No.	Plan Sheet No.	COMMENT	Responsible Company	RESPONSE
Pg. 1	The Landscape Plan must confirm through depicted calculations that the General Landscaping Standards of 5-6(C) of the IDO are met, the Street Frontage Landscaping requirements of 5-6(D) of the IDO are met, the Edge Buffer Landscaping requirements of 5-6(E) of the IDO are met, and the Parking Lot Landscaping requirements of 5-6(F) of the IDO are met.	HPD		Calculation table revised to refer to ordinance section and street frontage / edge buffer calculations added. Site is an existing commercial development fronting 2 roadways and buffered by commercial drive aisles on the other 2 sides. Alameda Blvd side (N) is beyond 20 ft curb zone and existing vegetation will remain in place for buffer. San Pedro side (W) provides trees where not in conflict with existing utilities. Edge buffer met on East side of development and existing vegetaion buffers South side. Parking lot calcs exceed 10% requirement.

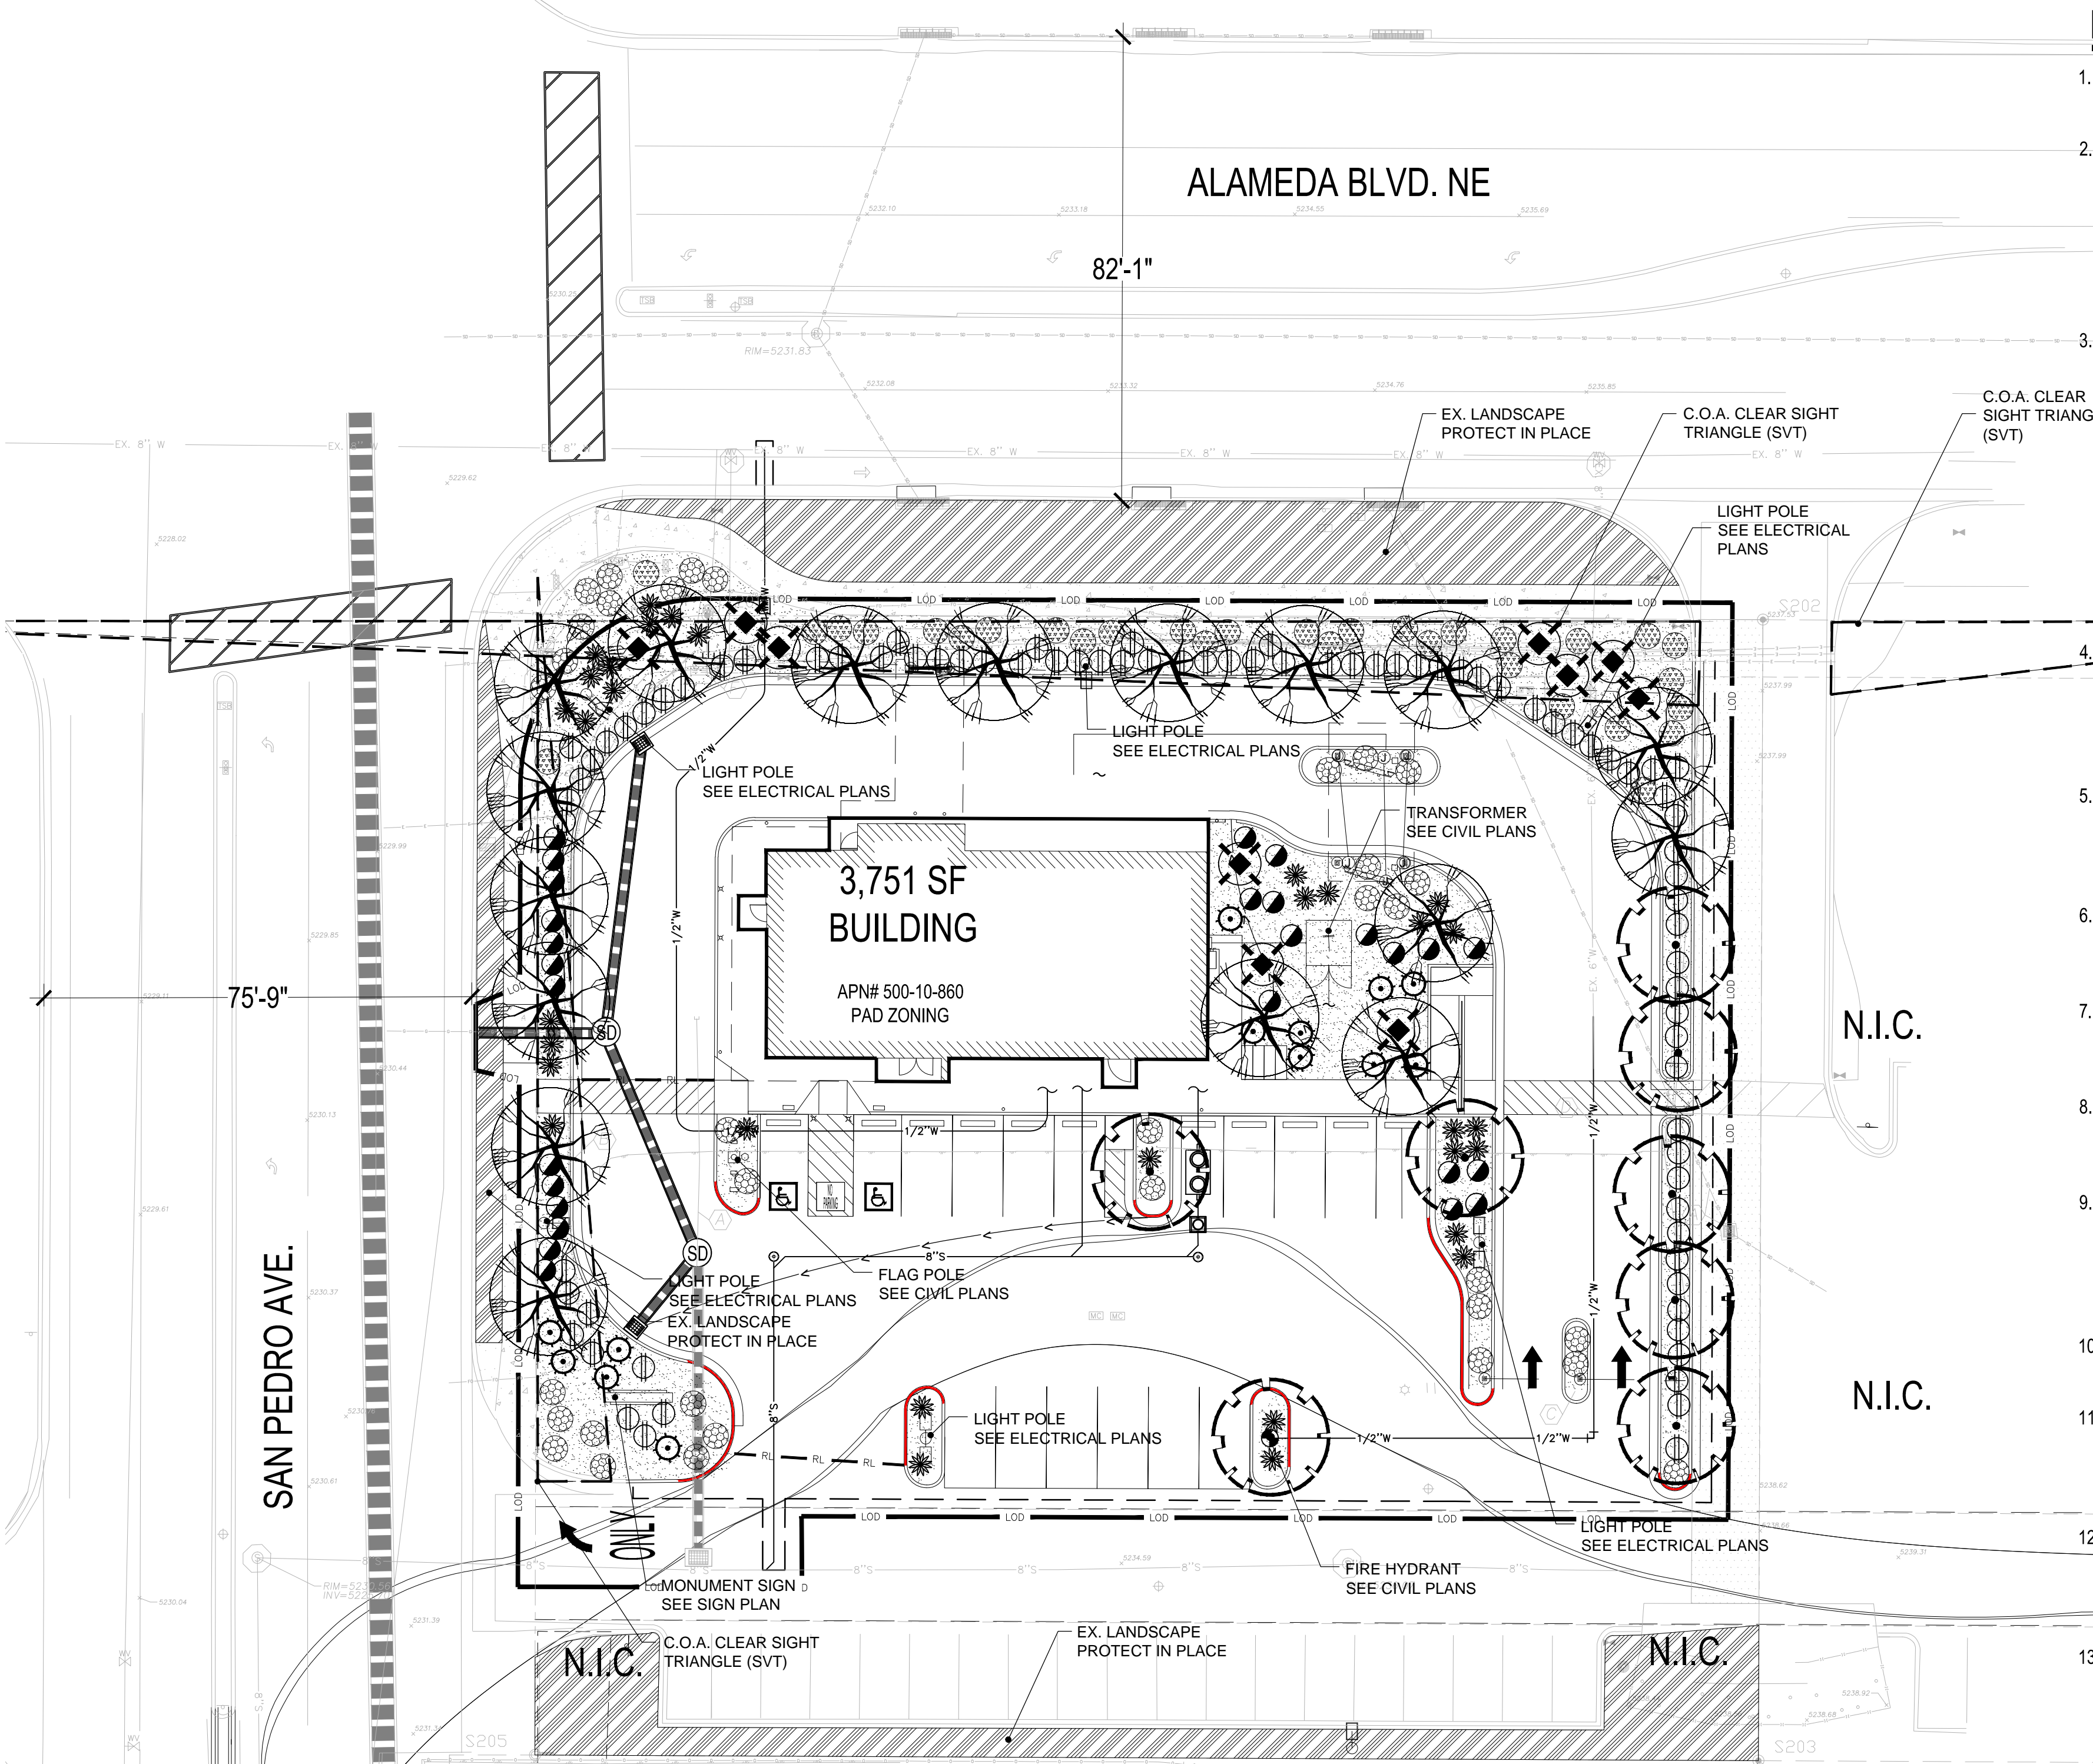
Pg. 2	Per 5-6(C)(4) of the IDO all trees and shrubs depicted on the Landscape Plan must be selected from the Official Albuquerque Plant Palette.	HPD		All plants are proposed from the ABCWUA.org xeriscape plant list
1	ID IDO section 5-5-(1)(2) indicates the Drive-Through lanes adjacent to Public ROW are required to have a Vegetative Screen or Wall. Landscape plan shows ground cover plants rather than shrubs in that area of the LS plan on L.1.1, and no wall is evident.	HPD		Understory plants replaced with evergreen shrub between evergreen trees to screen visible direction of menu signs. Yellow Bird of Paradise utilized.
Pg. 1	Per IDO 5-6(D), street trees required 20-ft from curb and approximately 25-ft on center. Albuquerque is currently USDA hardiness zone 7. Some species listed on the Landscape Plan have hardiness zones higher/warmer than what currently exists in Albuquerque and should be exchanged. IDO Section 5-6(D)(1)(b) requires tree species to be recommended on the Official Albuquerque Plant Palette (linked here: Official Albuquerque Plant Palette and Sizing List-2018-07-03.xlsx (cabq.gov)). And the Nature Conservancy has a Climate Ready list (linked here: NM_ClimateReadyTrees.pdf (nature.org)). The Parks and Recreation Department prefers species cross-referenced. (Please contact me at csomerfeldt@cabq.gov with any questions).	HPD		Trees revised to use Escarpment Oak and Chaste Tree (approved materials from tree list).

Pg. 1	Please include planting detail for trees to include a note per IDO Section 5-6(C)(5)(e).	HPD		Planting detail added to preliminary sheet. Permit package will provide all install details for landscape and irrigation.
